**KIRKLEES METROPOLITAN COUNCIL
INVESTMENT & REGENERATION SERVICE**

Reference No:	2023/62/90630/W
Site Address:	53, Greenhead Road, Huddersfield, HD1 4ER
Description:	Erection of two storey extension
Recommending Officer:	Tom Hunt

DECISION – REFUSED

Officer Report

Project Name 53 Greenhead Road, Huddersfield, HD1 4ER	
Drawing Title: Proposed Location And Site Plan	
Drawing Number: TR-A22-1101-005	Scale: As indicated@A1
Date: 06/03/23	Revision: C
Drawn By: AM	Checked by: JA
Reason For Issue: Planning

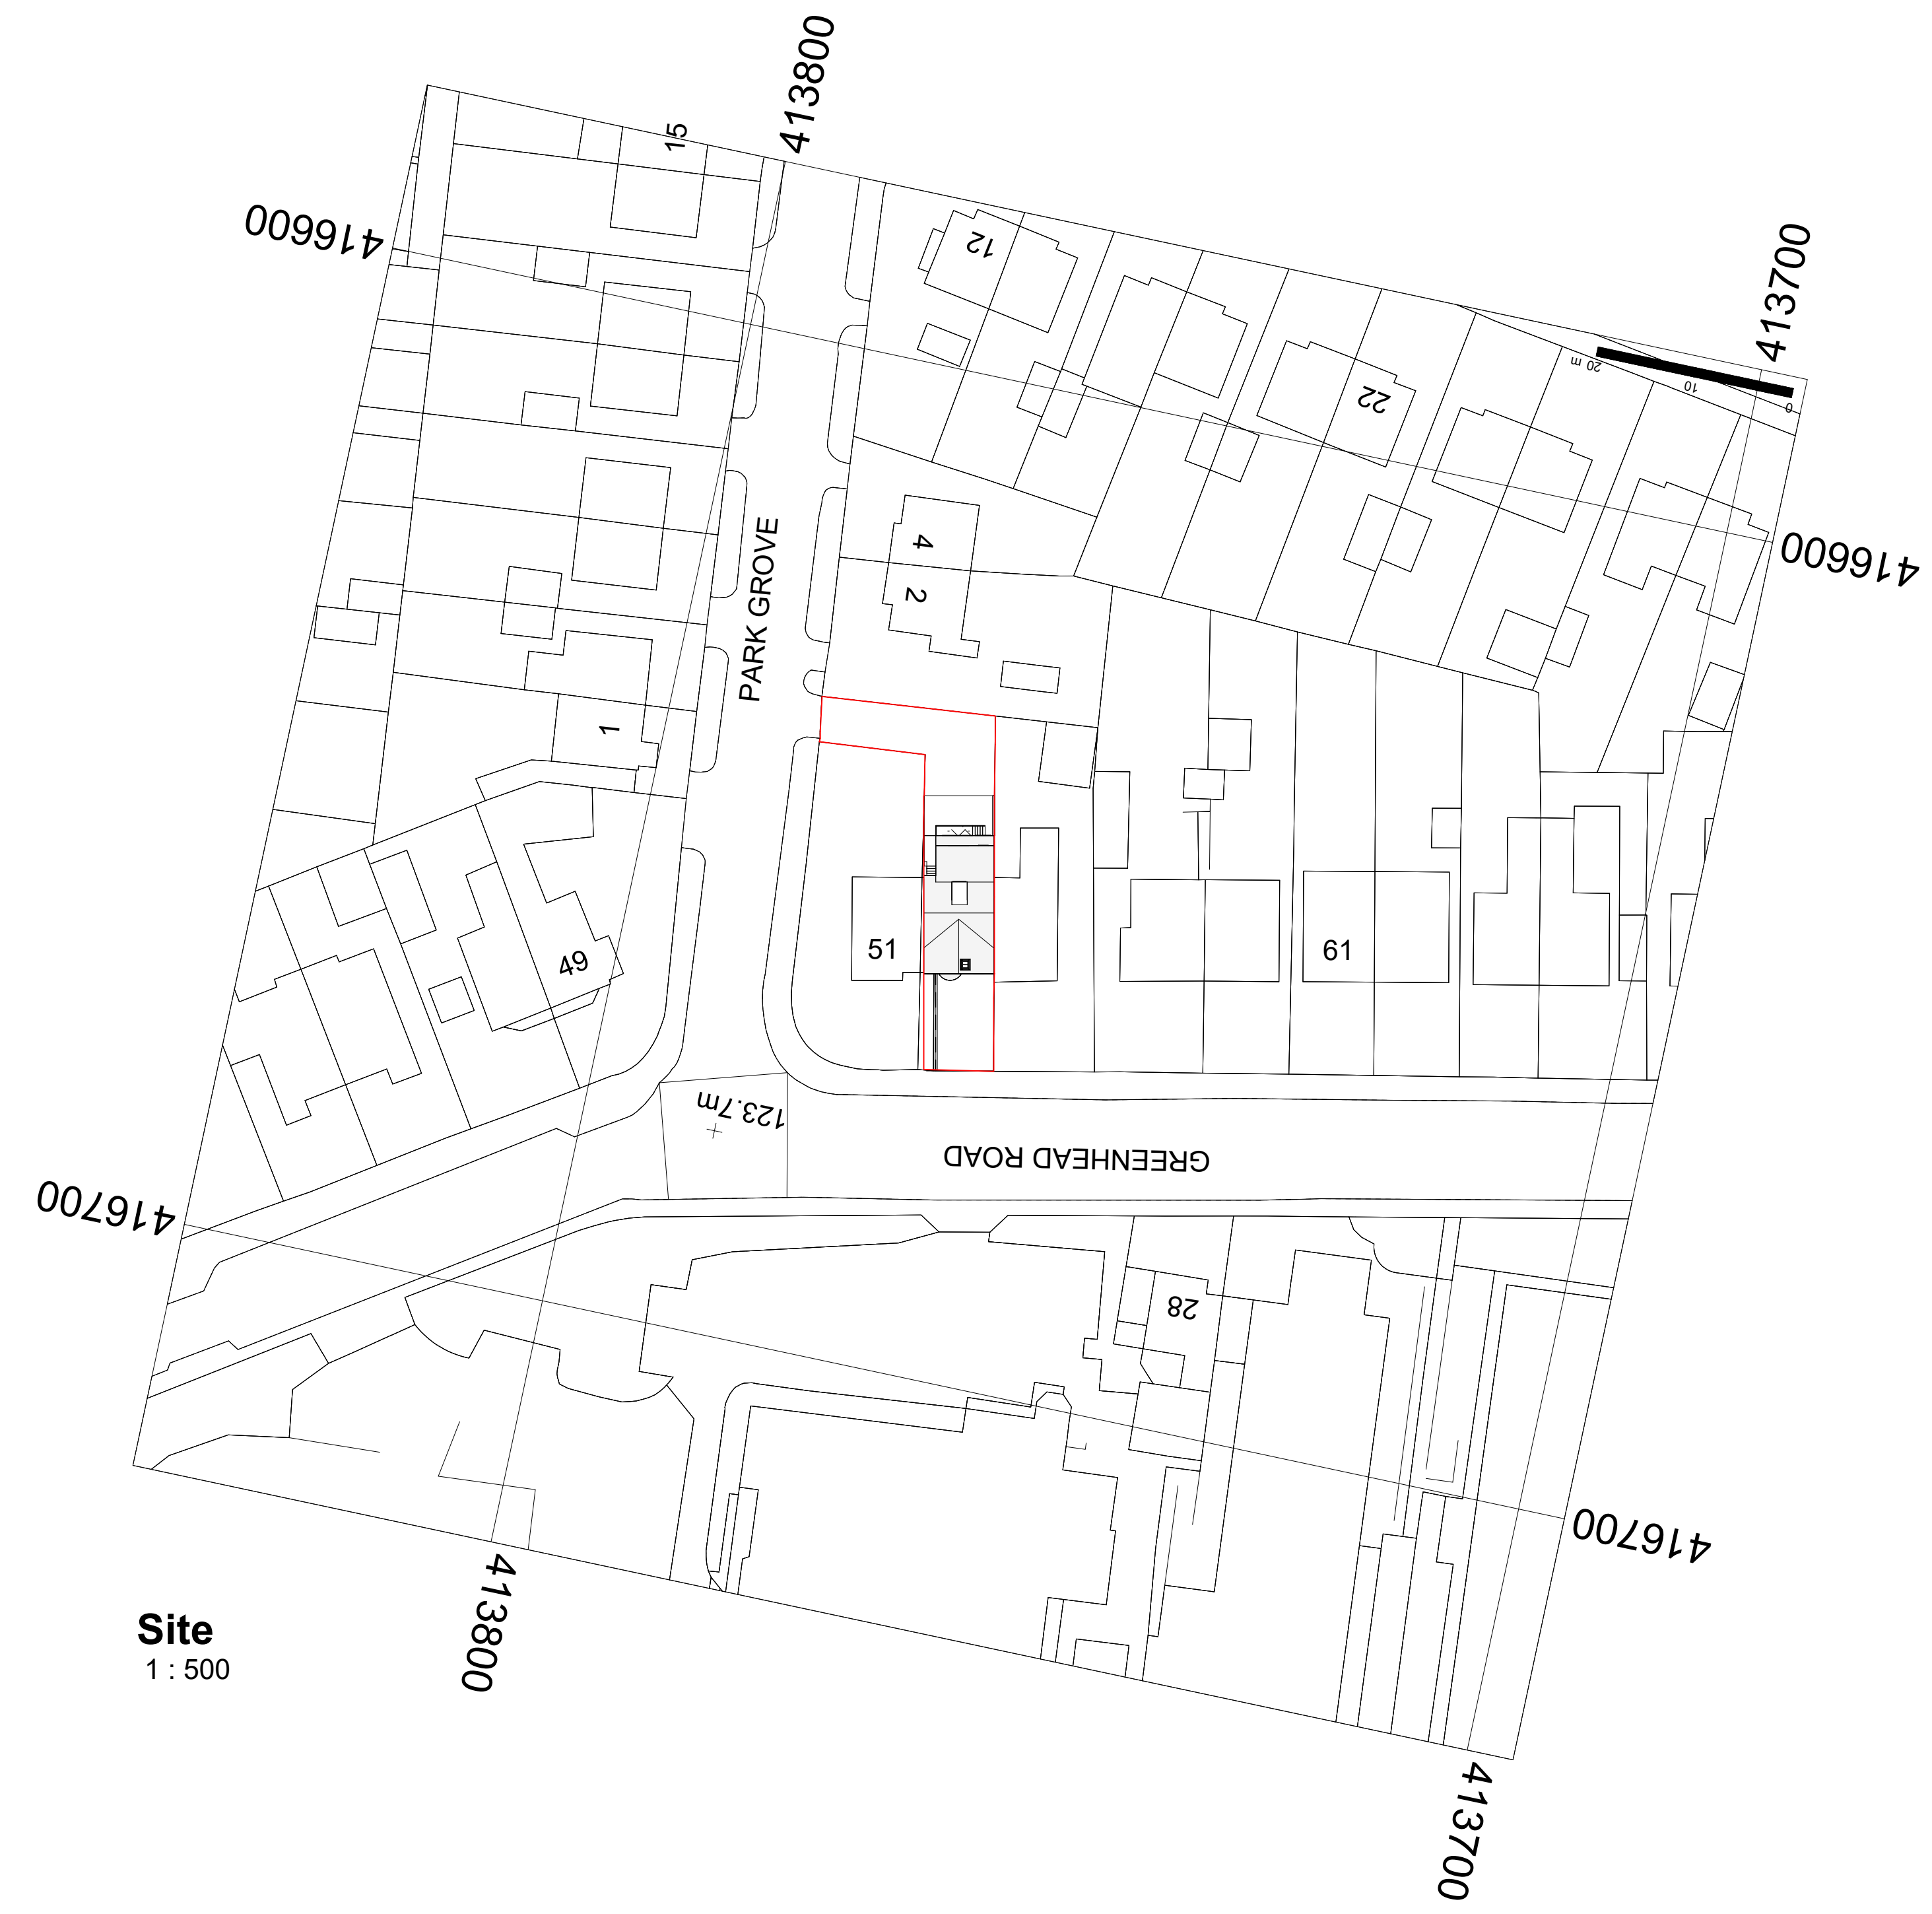
It would maintain external access to the rear garden however would fail to preserve a rear garden proportionate to the size of the host eroding the original character of the host's rear garden leaving it to be dominated by parking/hard surface to the rear.

The Highways Design Guide advises that proposals should have sufficient off-street parking spaces to meet need and to ensure on street parking impact is limited. For a 3 bedroom dwelling, it should have a minimum of 2 off street parking spaces which it appears to have from the assessment of the site plan.

While no bin arrangements have been set out, the site plan indicates that there is sufficient remaining space and external access to the garden to have the bin arrangements remain as existing.

Front
1 : 50

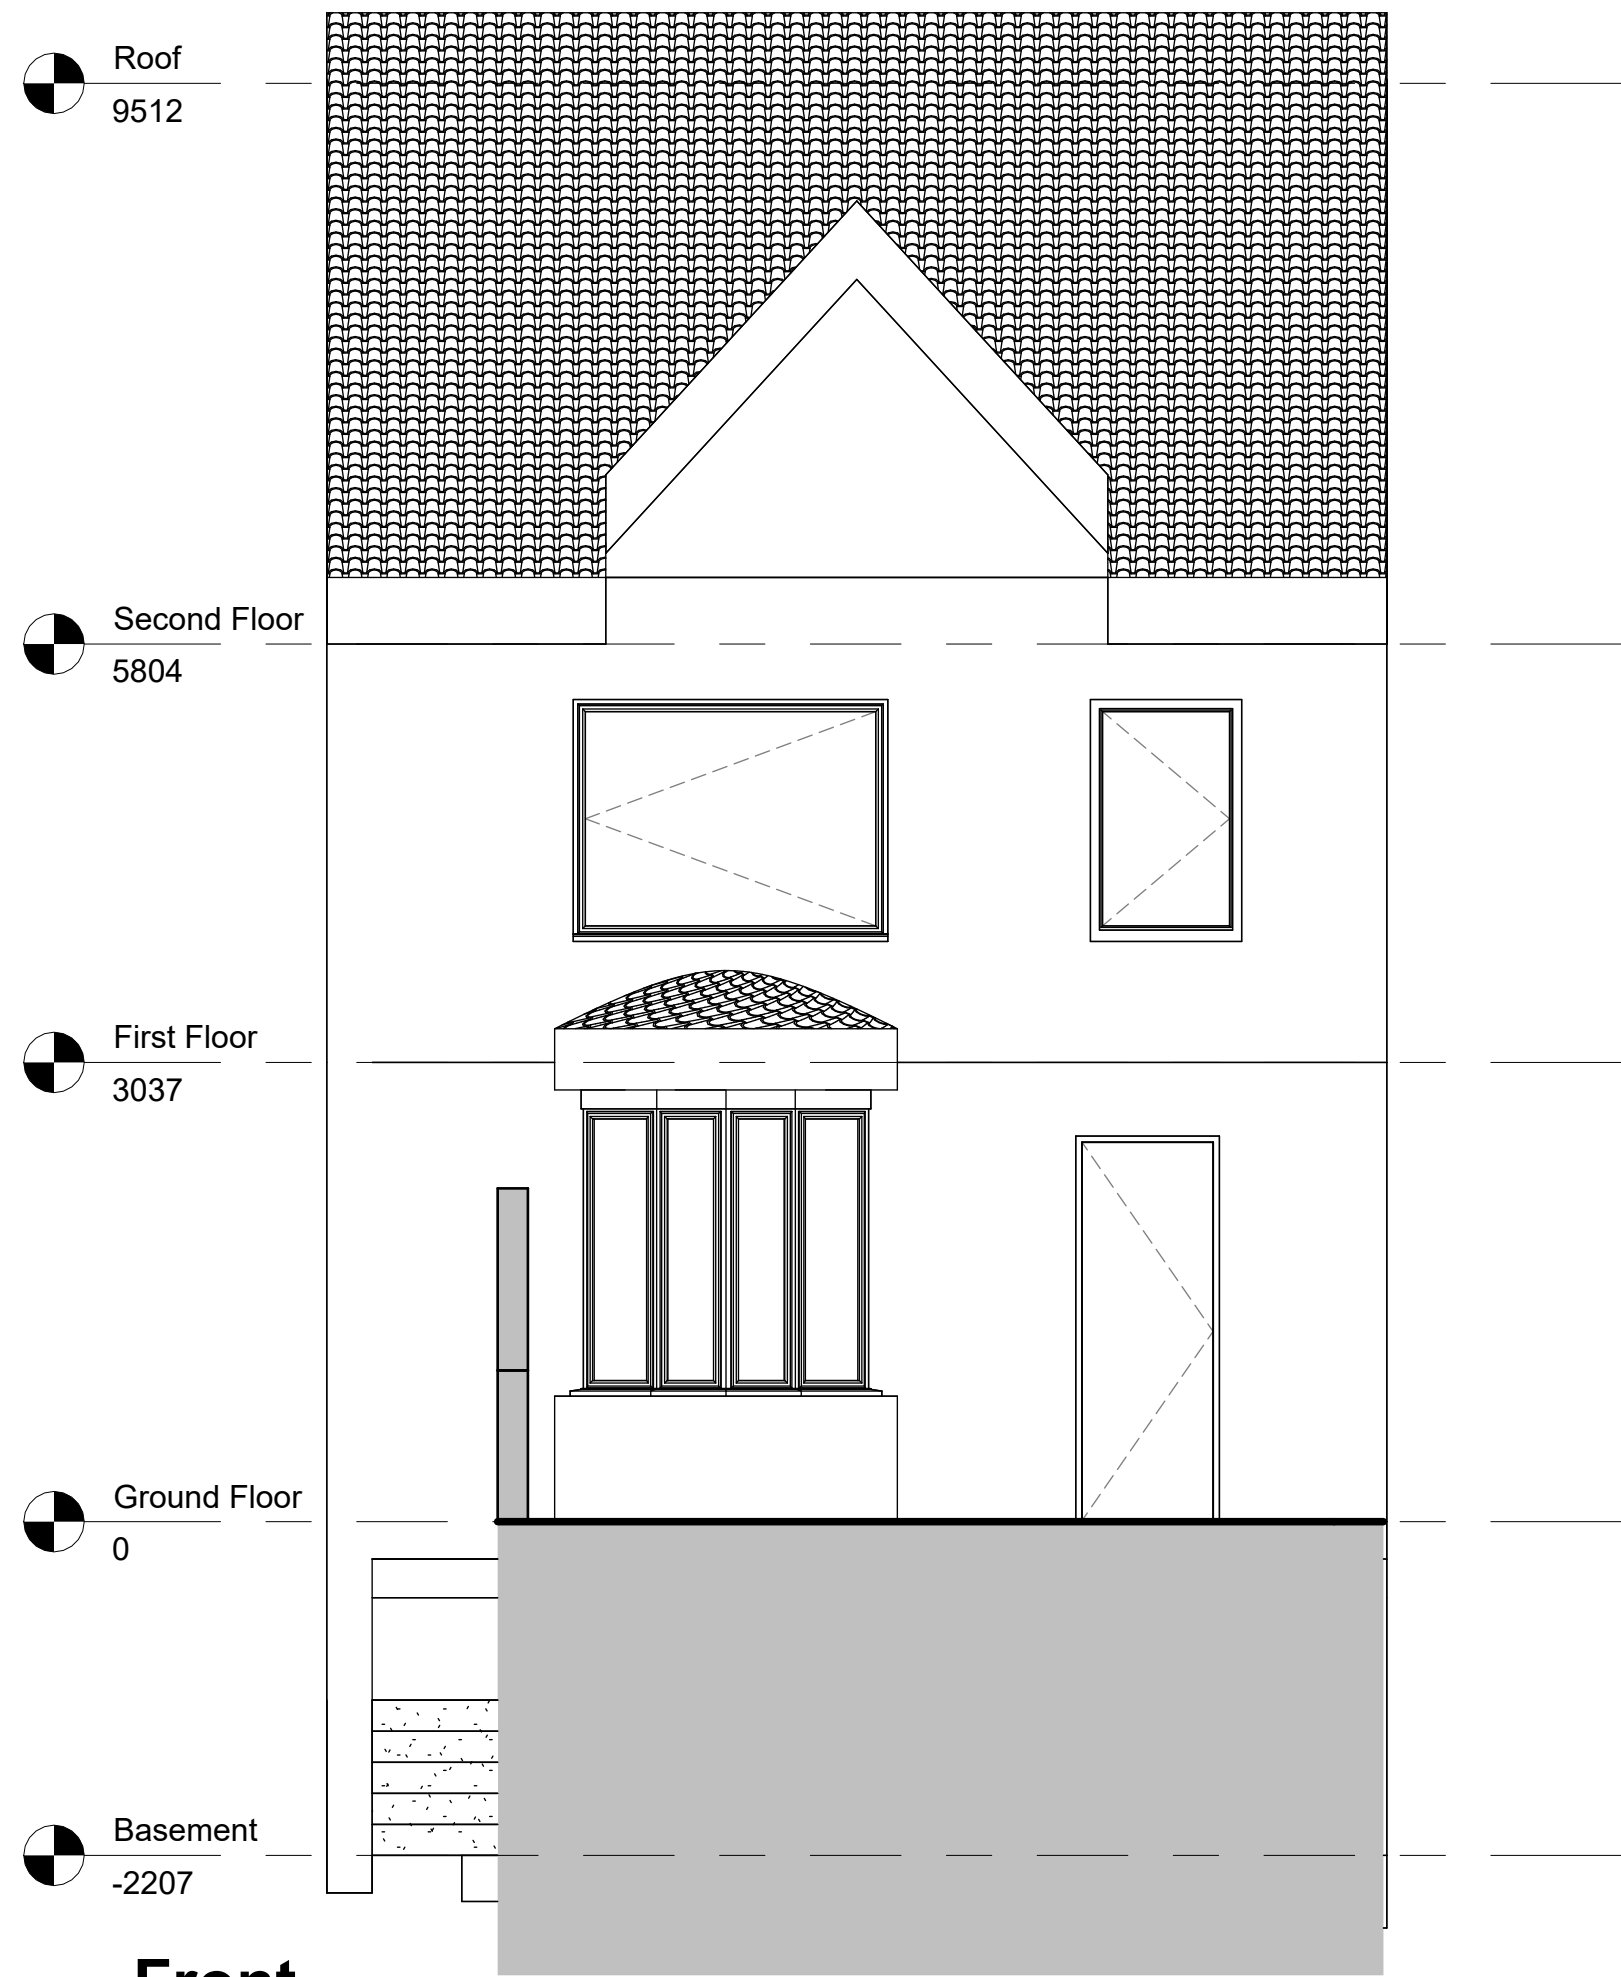
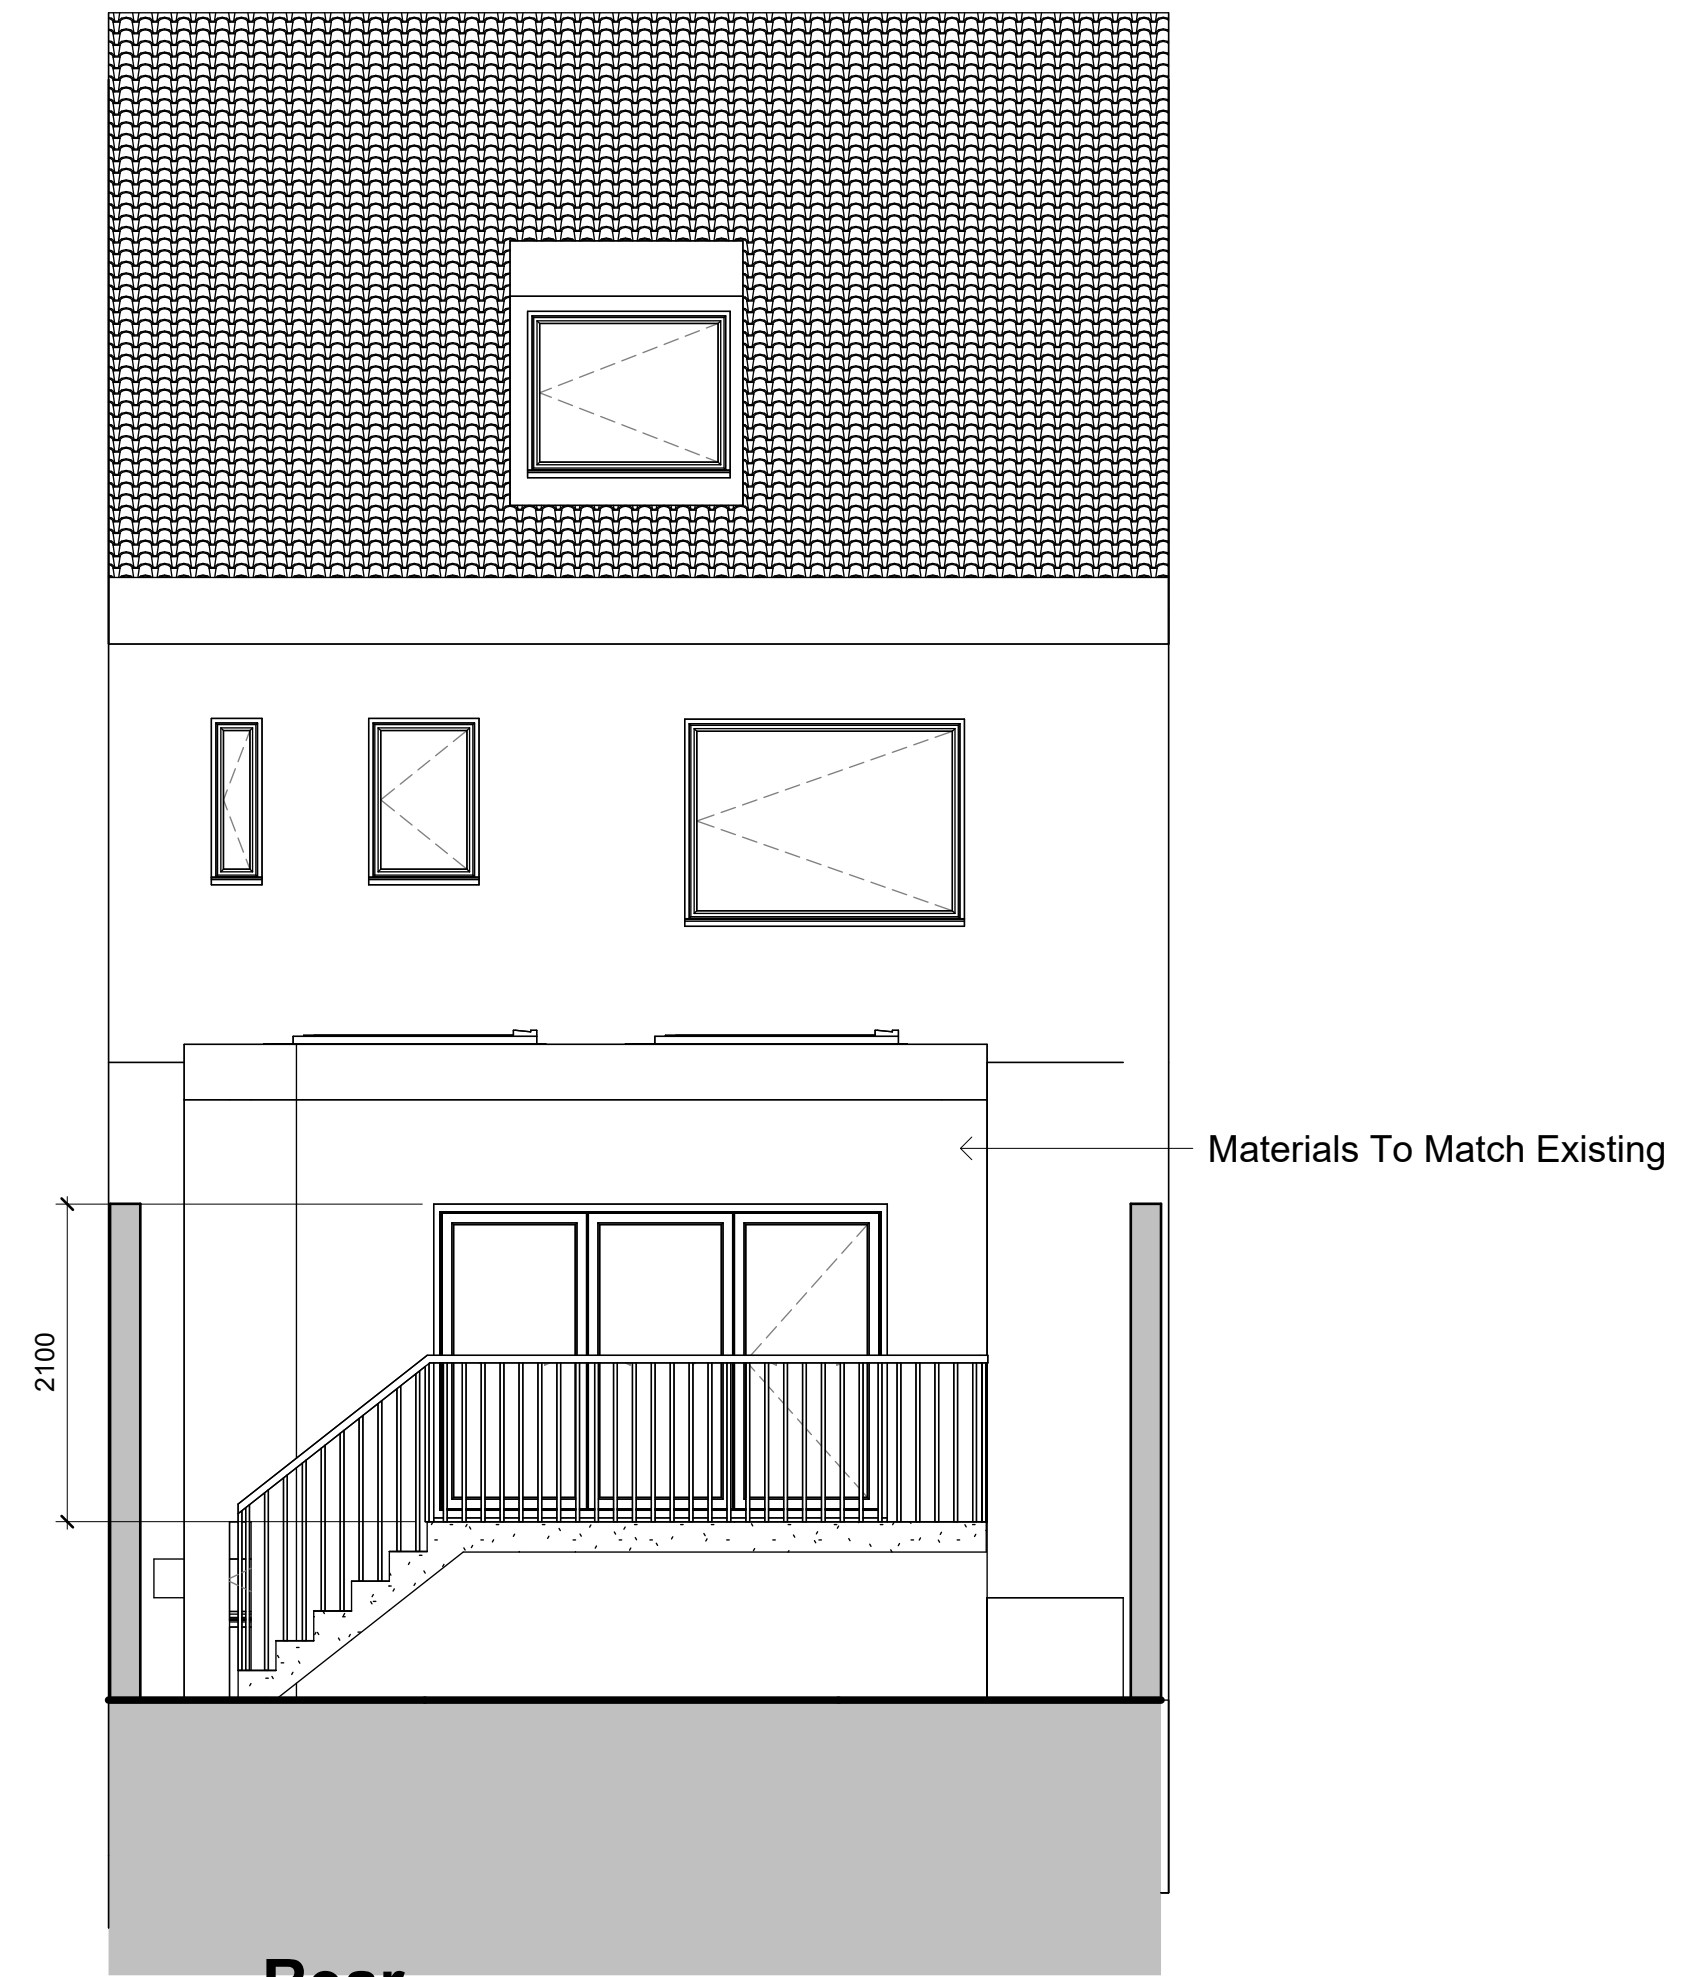
Officer Note: Existing elevation plans do not show the full extent of the gable end front feature and the proposed elevation does not definitively set out the proposed height of the rear raised area with steps.

The agent was contacted regarding plans which did not accurately set out the front elevation of the host building and had this in part corrected within submitted proposed plans. In relation to Officers concerns over the design and other considerations, the agent was not contacted during the course of the application as the scale of considered necessary would materially change the development applied for.
